Office of
Environment
& Heritage

DOC18/912194
SSD-9274

**Samuel Gilbert Public School redevelopment – Corner Ridgecrop Drive and Gilbert Road
Castle Hill (SSD 9274) – Environmental Impact Statement**

Attachment A

Figure 10 - Asset Protection Zone Plan

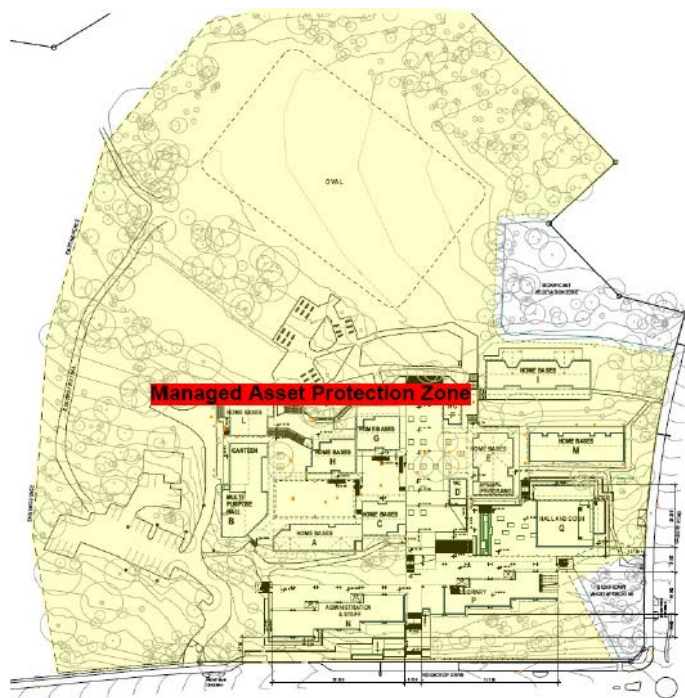
The BPA notes the school site is managed as an Inner APZ except for the two remnant areas of STIF and this will continue in the future (see Figure 9 and section 4.7, page 20). The proponent needs to clarify if the revegetated area(s) of STIF will be managed as an Inner APZ, as the BDAR recommends revegetating native understorey commensurate with STIF to achieve a maximum of 15% cover for APZ compliance (Section 5.4, page 58). If the revegetated STIF is proposed to be managed as an APZ, the proposed removal of STIF will not be adequately mitigated. If the development is approved OEH recommends the following Condition of Consent is included:

- the existing areas of STIF and revegetated areas of STIF must not be managed as an APZ.

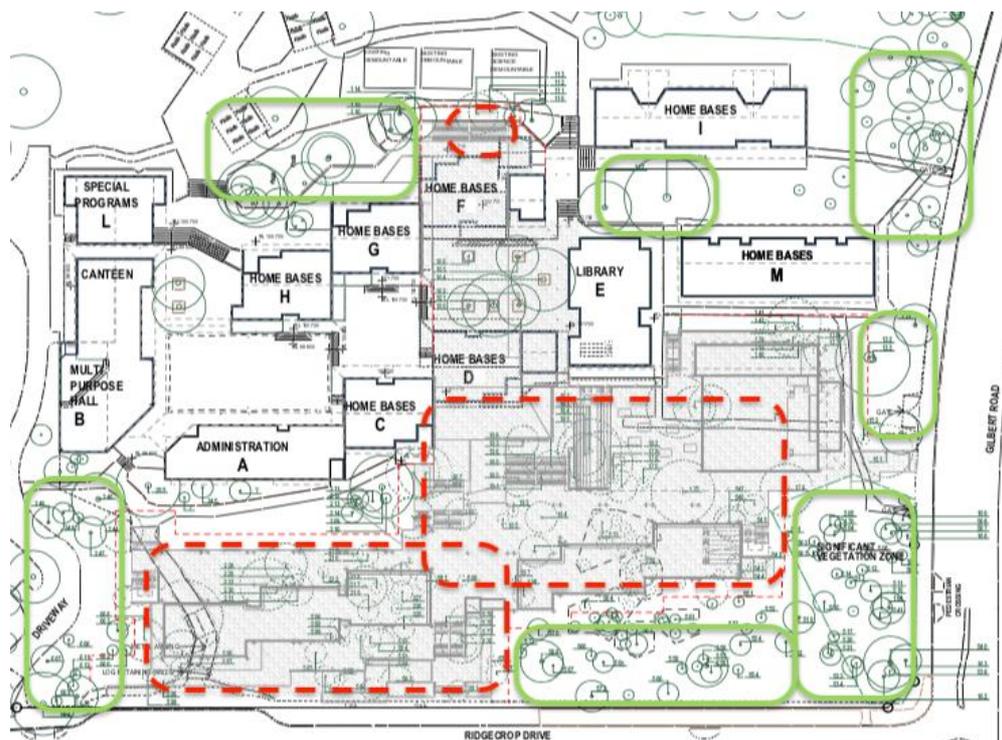
The AIA notes that the definitive number of trees requiring removal is difficult to determine at this stage (section 5, page 9). It also indicates 77 trees within Building Envelope (including 3 metres beyond the platform) are proposed for removal (page 10) while Appendix E2 indicates 87 trees are to be removed. The proponent needs to clarify the number of trees likely to be removed by the project.
